From: Sarah Sutcliffe [REDACTED]
Sent: 11 February 2019 08:44
To: Anita Gardner
Subject: FW: Land South of Cornfields Close, Littlehampton, BN17 6LD (REF: HA/2018/120921/01-L01)
Importance: High

Subject: Re: Land South of Cornfields Close, Littlehampton, BN17 6LD (REF: HA/2018/120921/01-L01)

Our technical team have reviewed the additional information provided and site investigation report, and we would respond as follows:

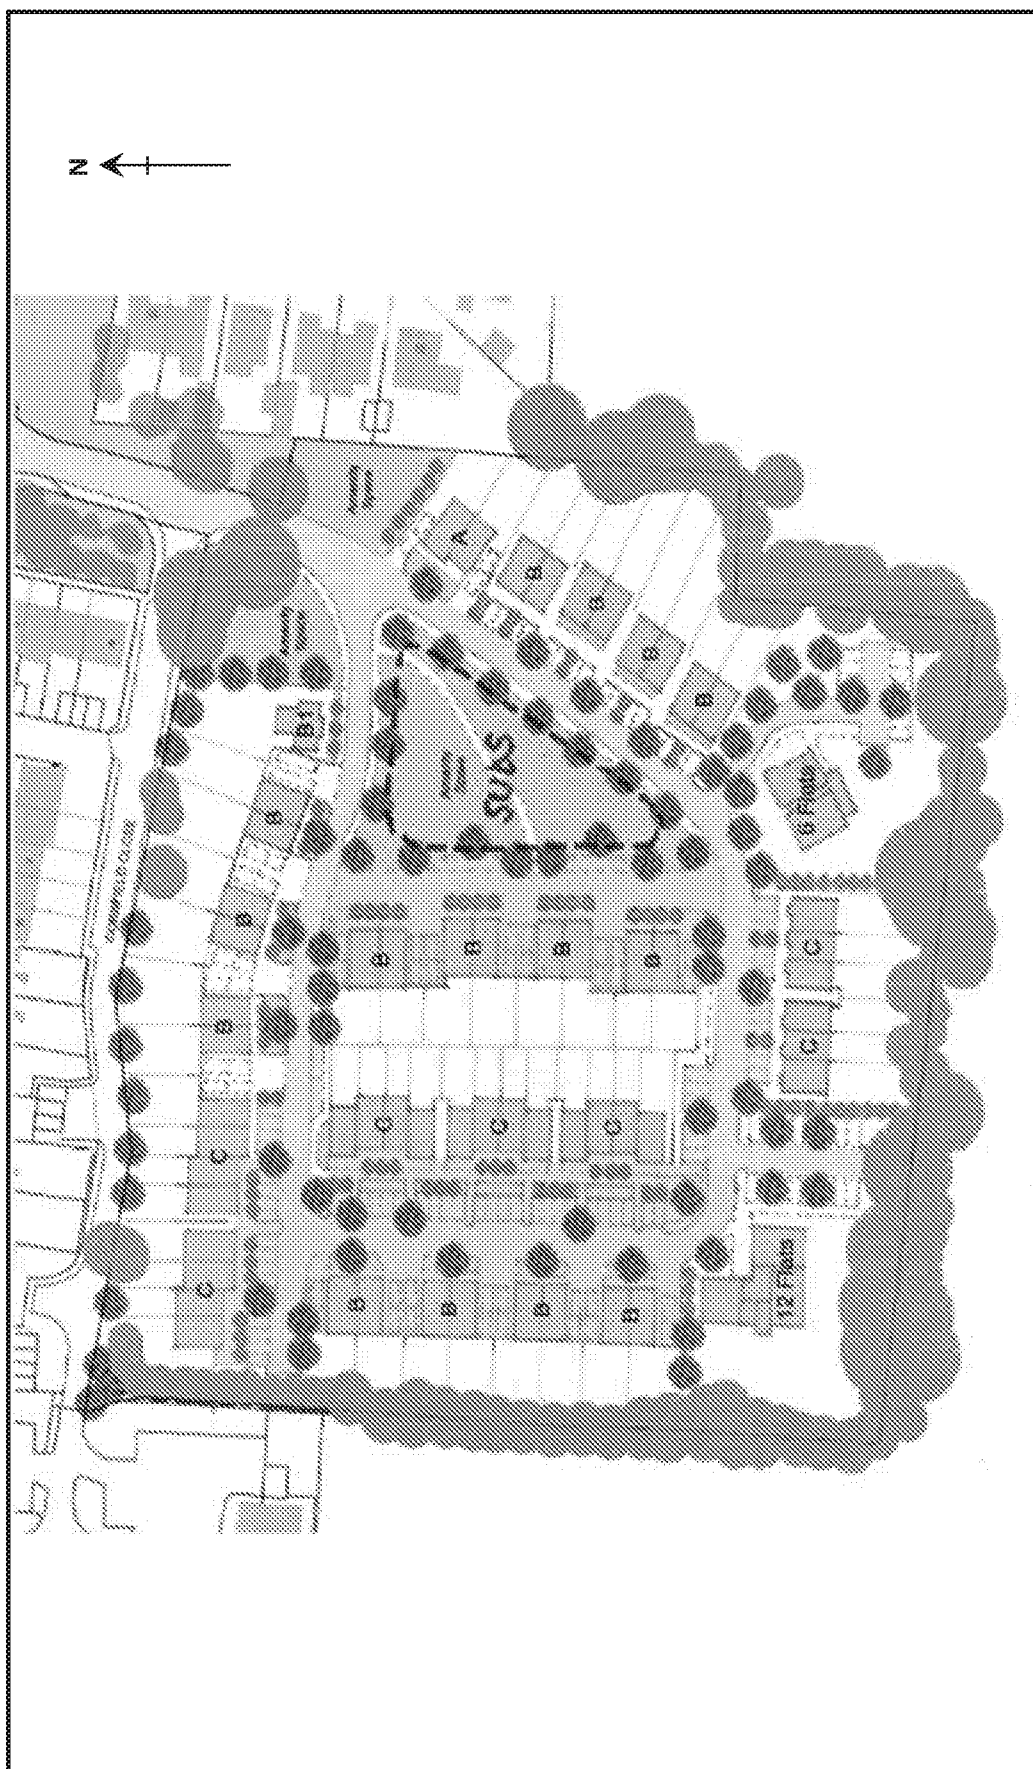
No drainage systems for the infiltration of surface water to the ground are permitted other than with the written consent of the local planning authority. Any proposals for such systems must be supported by an assessment of the risks to controlled waters. The development shall be carried out in accordance with the approved details.

The previous use of the proposed development site as Brick Kiln and Landfill presents a high risk of contamination that could be mobilised by surface water infiltration from the proposed sustainable drainage system (SuDS). This could pollute controlled waters. Controlled waters are particularly sensitive in this location because the proposed development site is located upon a principal aquifer. In light of the above, we do not believe that the use of infiltration SuDS is appropriate in this location. We therefore request that the above planning condition is included as part of any permission granted. Without this condition we would object to the proposal in line with paragraph 170 of the National Planning Policy Framework because it cannot be guaranteed that the development will not be put at unacceptable risk from, or be adversely affected by, unacceptable levels of water pollution.

Previous correspondence with Simon Deacon at the Environment Agency (see attached), detailed a soakaway construction methodology for the site that entailed storm water being dispersed via a chamber/crate system which would be designed so that the discharge would be vertical only into the superficial natural uncontaminated soils. Full details are presented in the FRA submitted by Glanville referenced: CV8171223/5McN/023, with an extract below:

All surface water run-off generated by hardstanding areas within the site will be conveyed to a soakaway, consisting of geocellular crates. The soakaway will be located close to the centre of the site, in the open public space. In accordance with EA recommendations, made ground will be removed from the area surrounding the soakaway before the installation. The base of the geocellular crates will be located at approximately 4.5m bgl, below levels where made ground is currently found. The sides and top of the soakaway will be lined, in order to prevent the mobilisation of any potential residual contamination from horizontal discharge from the soakaway. The design of the soakaway is therefore in accordance with EA guidance and site-specific recommendations and will not mobilise any residual contaminants within the site soils which may adversely affect groundwater.

A sketch of the proposed design principle is attached. As stated above, the infiltration will only be vertically into the natural uncontaminated soils to mitigate the risk to controlled water.
